RE: PROPOSED CONVERSION OF EXISTING INTEGRAL GARAGE TO HOME OFFICE INCLUDING ASSOCIATED INTERNAL AND EXTERNAL ALTERATIONS, TOGETHER WITH A 2-BAY DETACHED CARTLODGE/GARAGE – THATCHED COTTAGE, CHURCH LANE, ALPHETON, SUFFOLK, CO10 9BL.

Date: 05/07/2021

Following our site visit and discussion of the proposed scheme as described above, you have instructed me to consider the potential impact the above-mentioned proposal may have on the significance, character, and historic fabric of the Grade II designated heritage asset listed as The Thatched Cottage.

Proposed Ground Floor Plan
Scale: 1:50

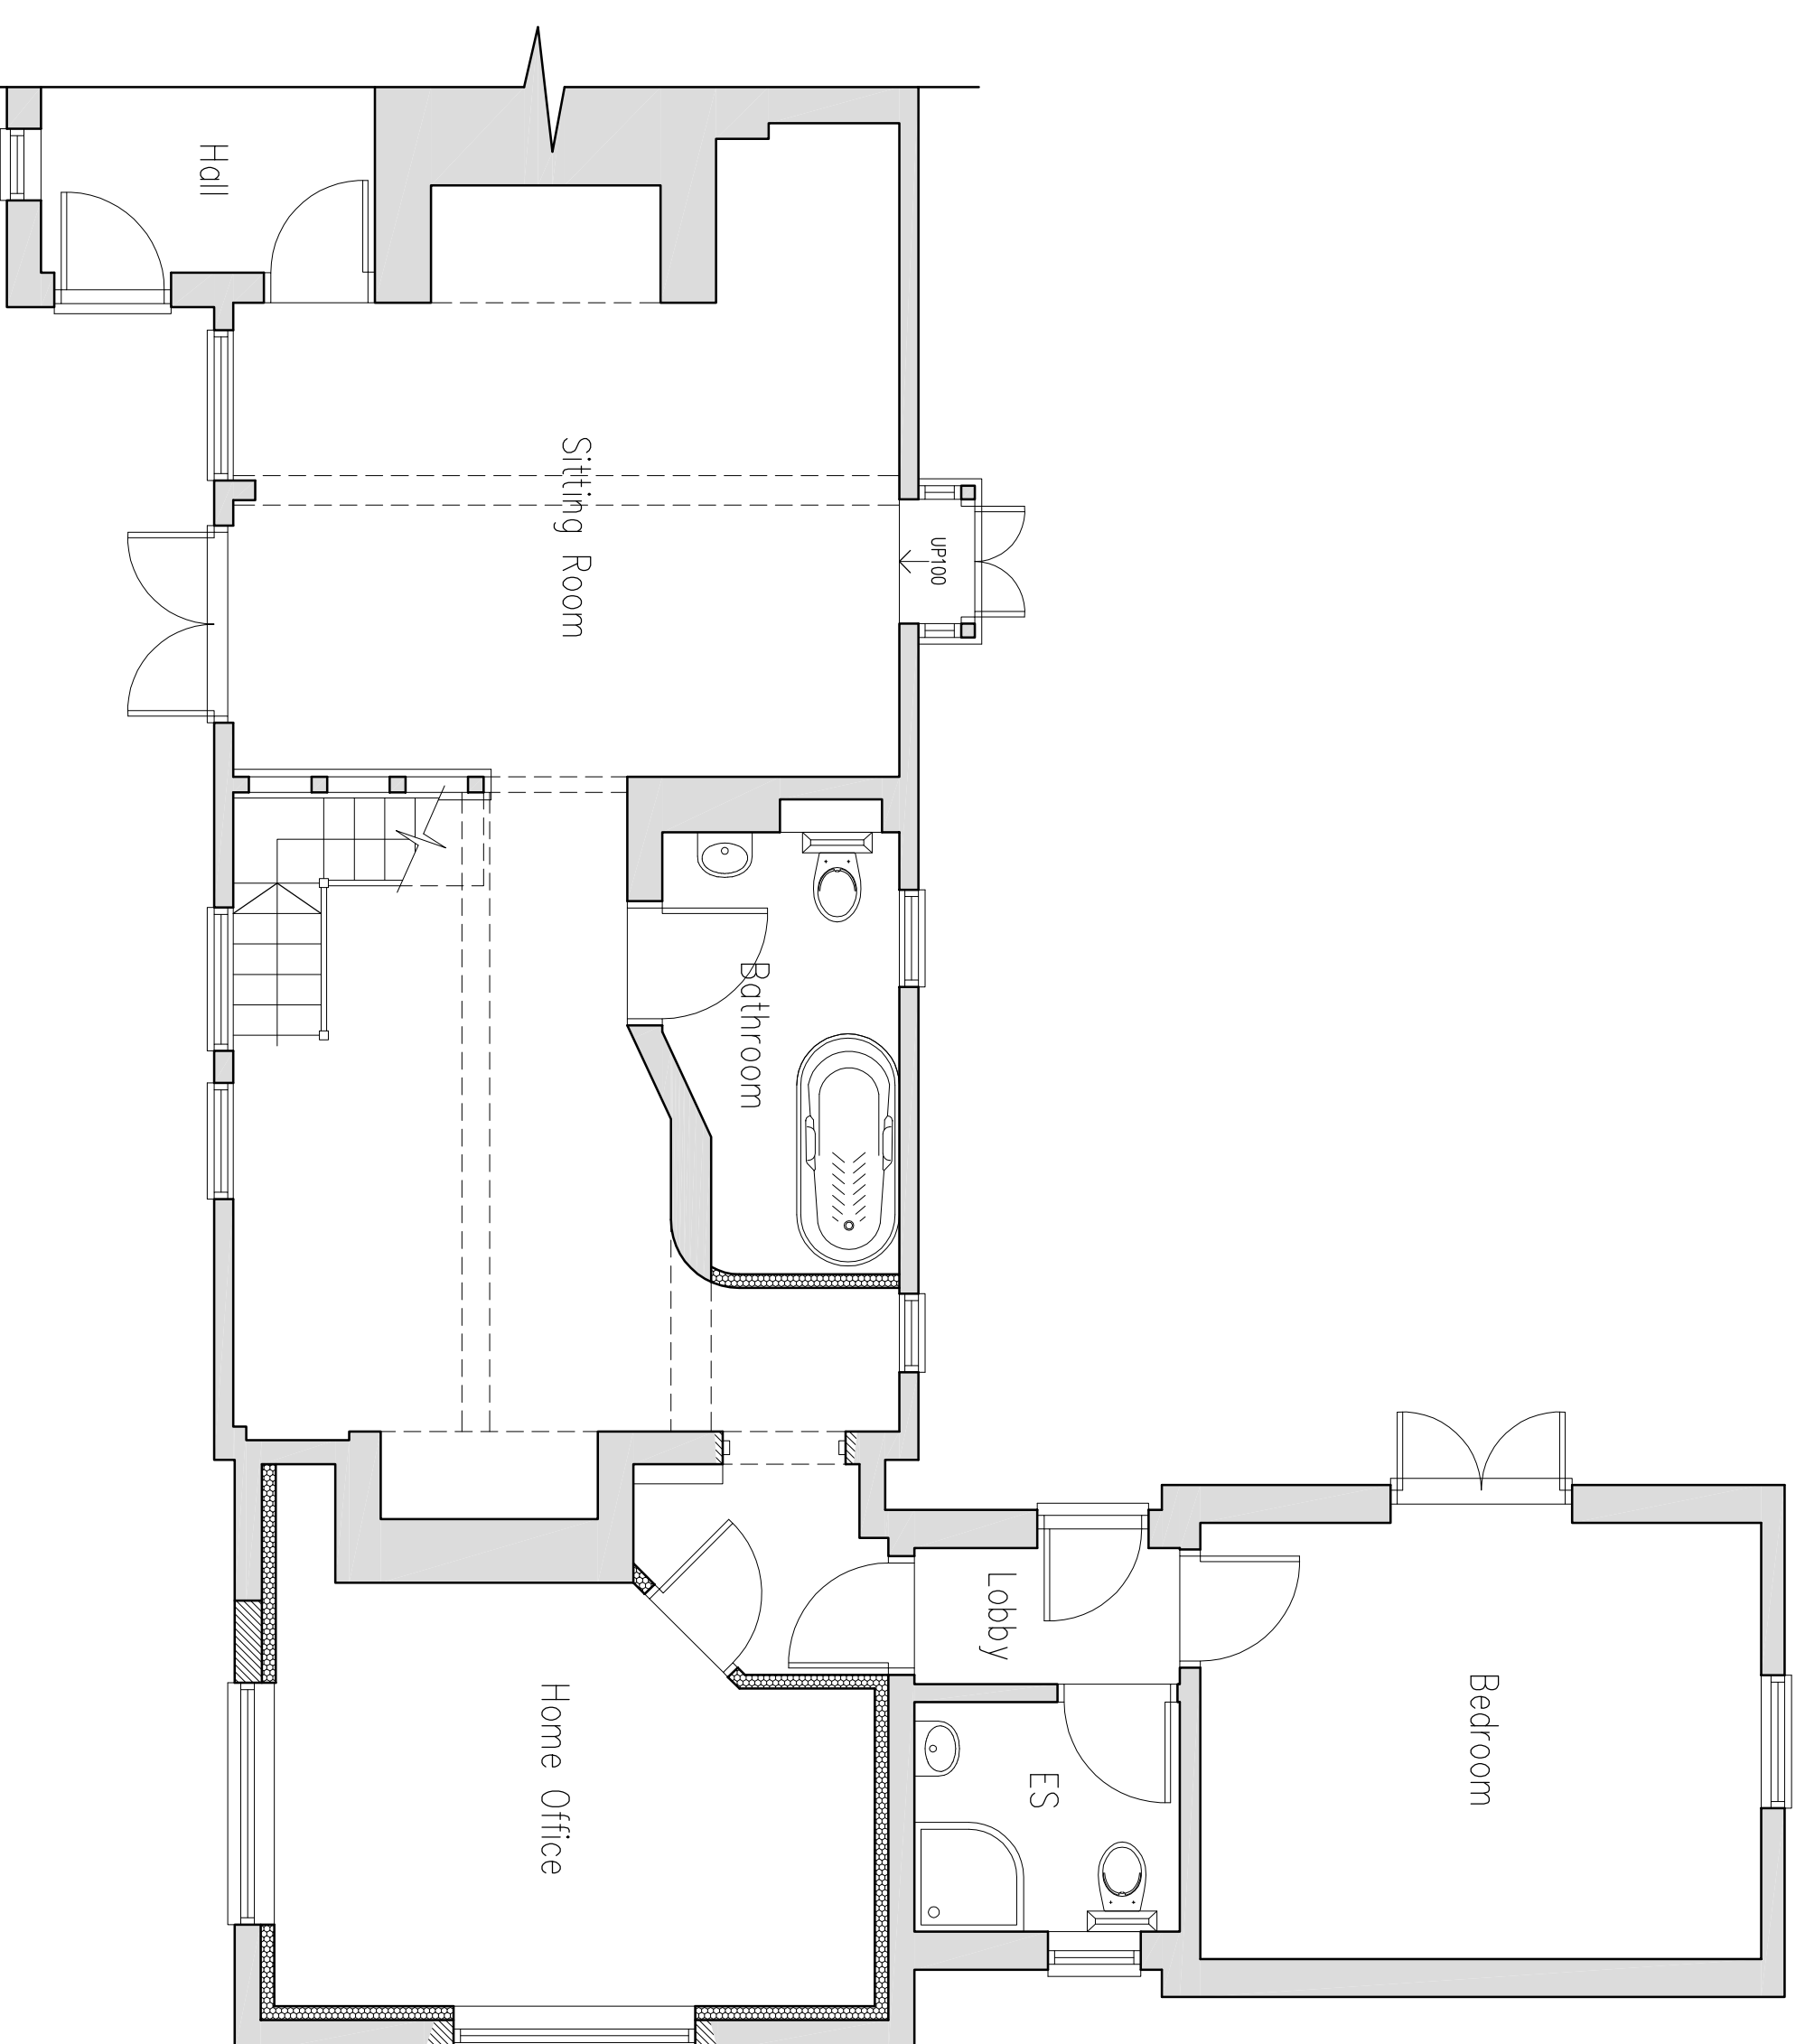
Comments on the scheme – The proposal includes only a minor alteration to the historic fabric of Thatched Cottage. It is proposed to form a doorway between the modern garage and the northeast end of the cottage, as well as altering the existing modern partition wall between the bathroom and secondary sitting room (snug) at the northeast end of the cottage. As shown in Fig. 12 the area proposed for a new doorway was altered during the 19th century when the original timber framing was replaced by brickwork. The exposed brickwork appears to suggest infilling of an earlier opening compared to the brickwork just to the right. The insertion of a doorway in this location

will have a negligible impact on the character and significance of the Grade II listed cottage.

It is proposed to convert the existing garage into a home office. This proposal includes the infilling and replacement of the existing garage doors with a casement window and internal alterations to the garage. The proposal will not detract from or harm the character of the Grade II listed building.

Proposed Site Plan
Scale: 1:200

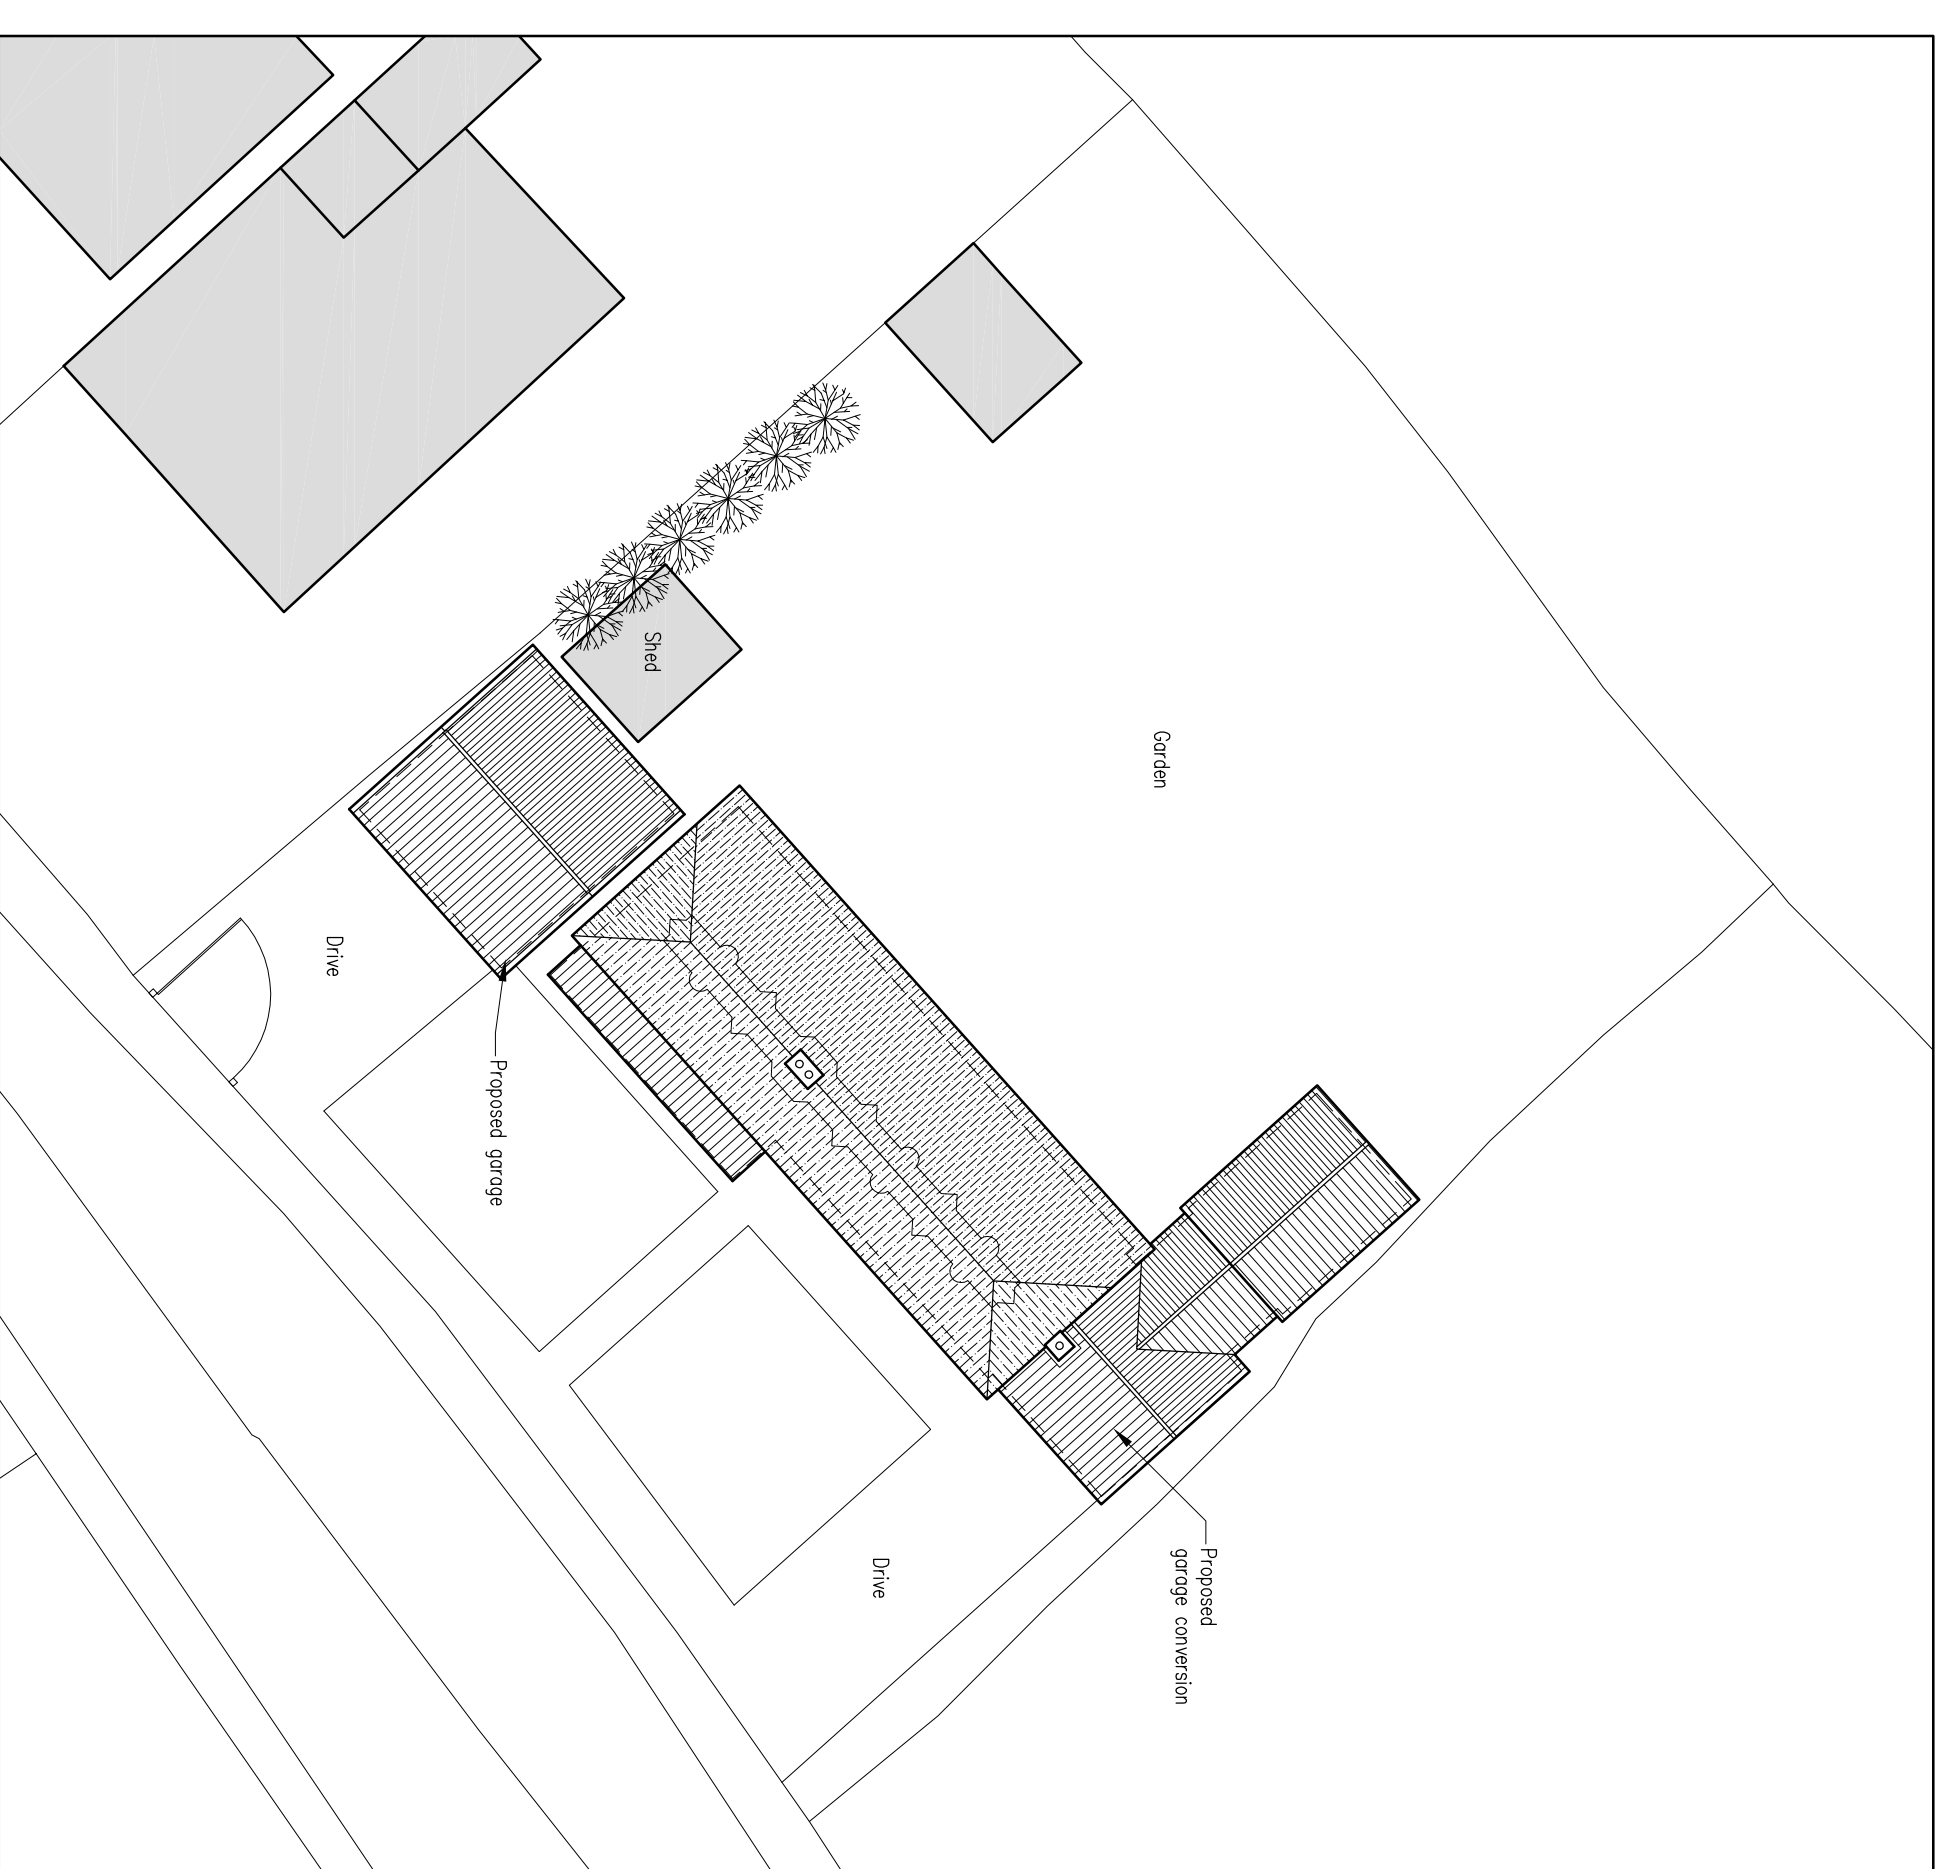
It is proposed to construct a 2-bay cartlodge/garage to the southwest of the cottage. I consider that the proposed cartlodge/garage poses a very low level of less than substantial harm to the Grade II listed building on account of its prominence within the setting of the Grade II listed building.
